Department of Economic Development and Planning
Attn. Mr John Macholc
1 November 2021

Dear Mr Macholc
Re: Planning Application No:3/2021/0955
Change of use of land from agricultural to proposed offices

drawing: Proposed Elevations

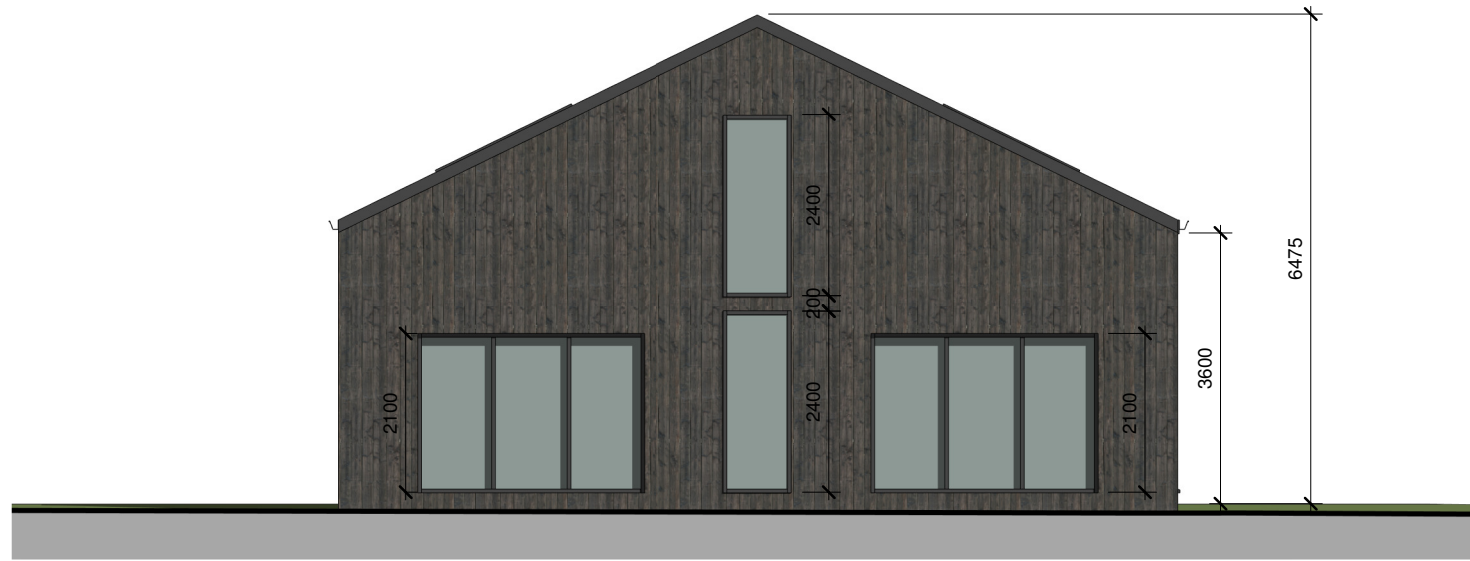
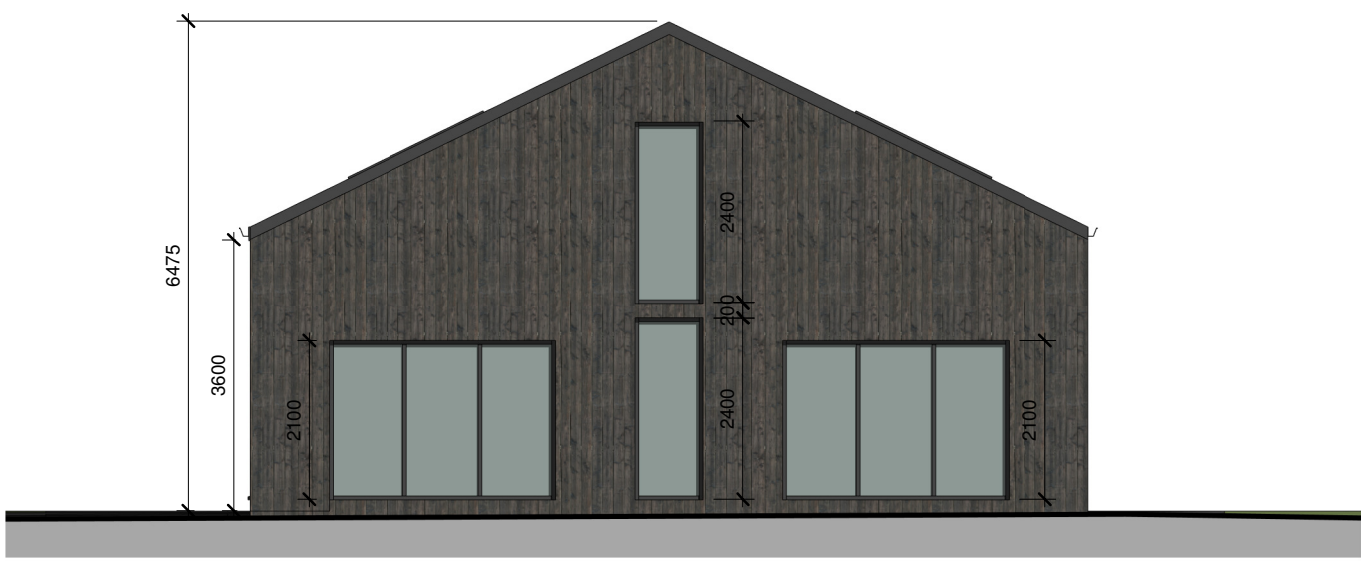
1. The ground floor level must match the floor level of the existing barns. This is not specified on the new plans.
2. The south face of the proposed offices not to exceed the building line of the existing original barn.
3. The height of the new offices not to exceed the eaves height and apex height of the existing barns.
4. The office plan be rotated with the windows facing in an Easterly direction.
5. Any external lighting to be at ground or low level with PIR activation during darkness.
6. Office hours to be specified.
